Application number: 2025/93126	
What is the application for?:	Demolition of rear block, erection of rear extensions and alterations to existin
Address of the site or building:	The Coach & Horses, Eastgate, Honley, Holmfirth, HD9 6PA
Postcode:

User comments

1 North-East Facing Elevation
1 : 50

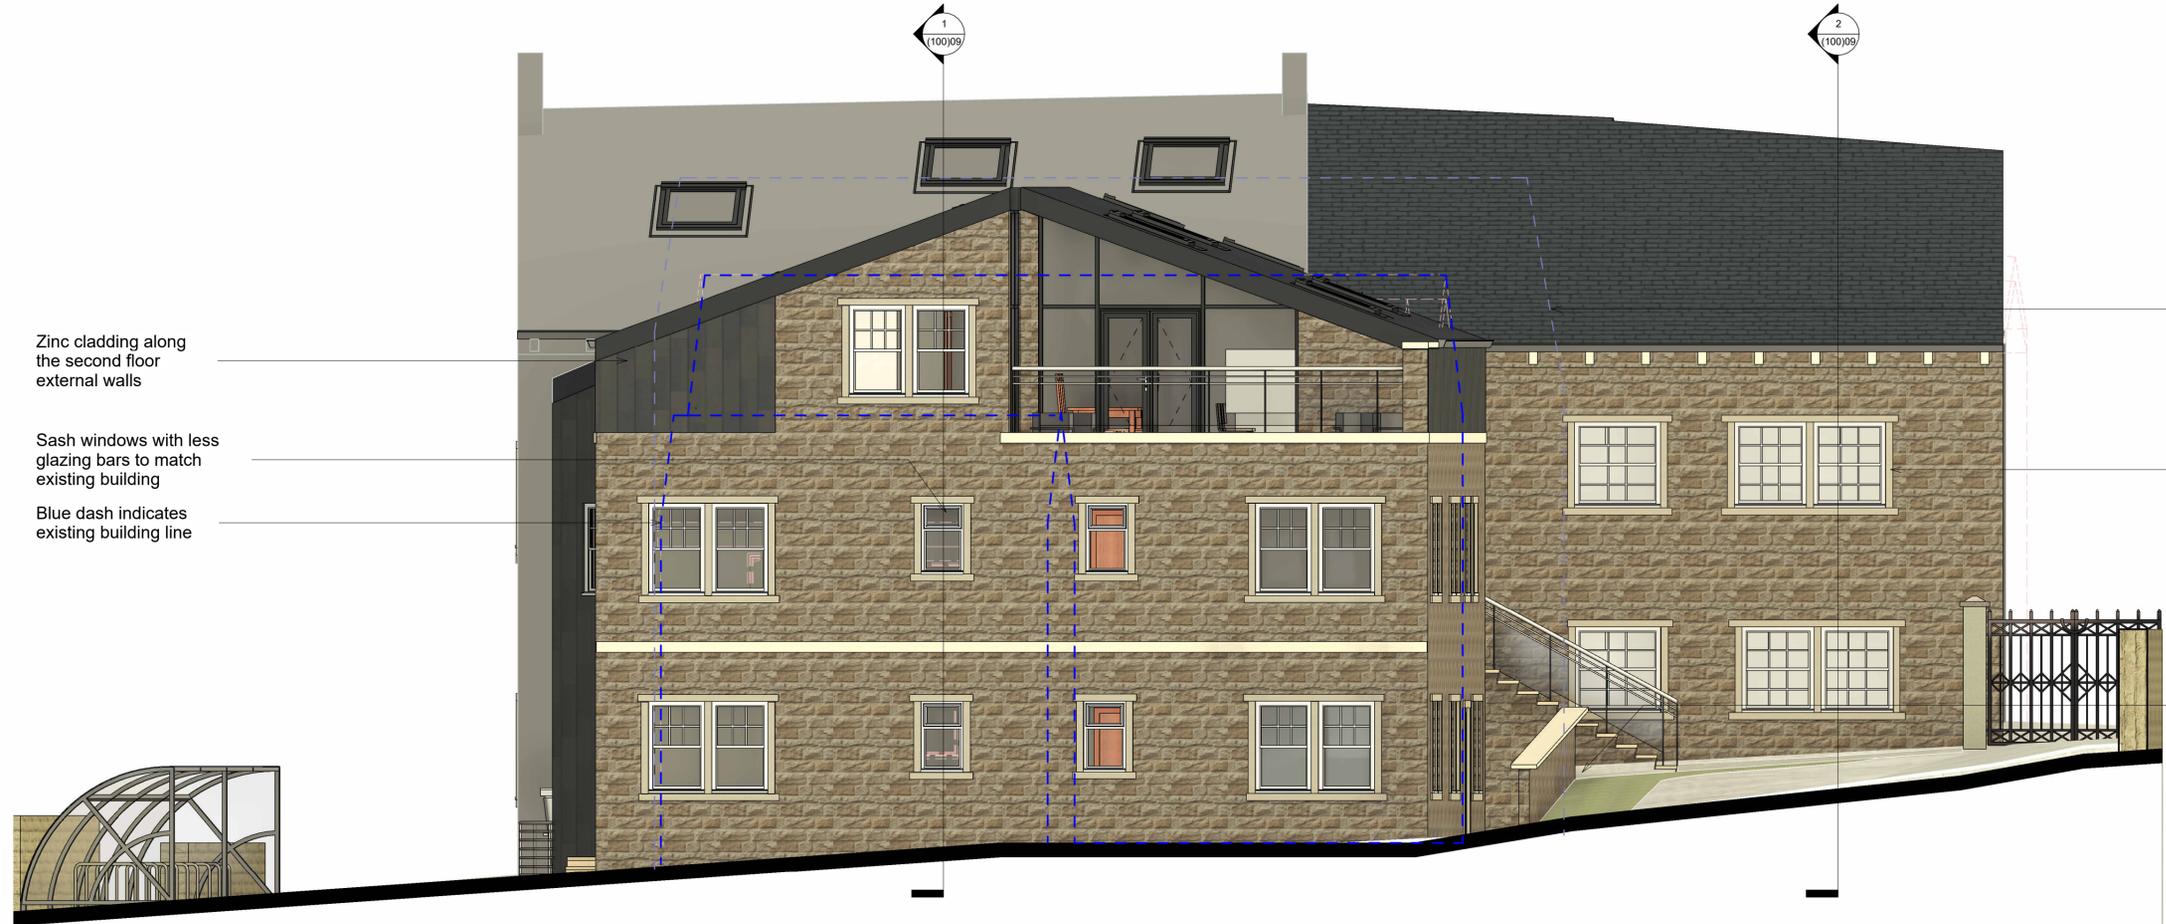
Type of comment: A general comment	
Do you wish your comments to be published on the website anonymously?	<input type="checkbox"/> Yes
<p>Whilst the use of the site for residential purposes is supported, the following issues are noted:</p> <p>The site as proposed is overdeveloped. For example, the number of parking spaces that can be provided is inadequate. Seven of the nine apartments have two bedrooms and potentially two cars per apartment. That could amount to 14 cars plus two from the two one bedroom apartments. Only 12 spaces are provided.</p> <p>Acumen stress that it is important that the front facade of the building remains untouched. However, a door is to be inserted on the left side of the frontage, the roof on this side is to be raised and a boundary wall that would be used for bin collection is proposed. In particular the wall detracts from the historic sweeping view and setting of the frontage.</p> <p>Reassurance is required that all windows across the facade will be six square sash type. Illustrations in the documentation do not show this for the left side.</p>
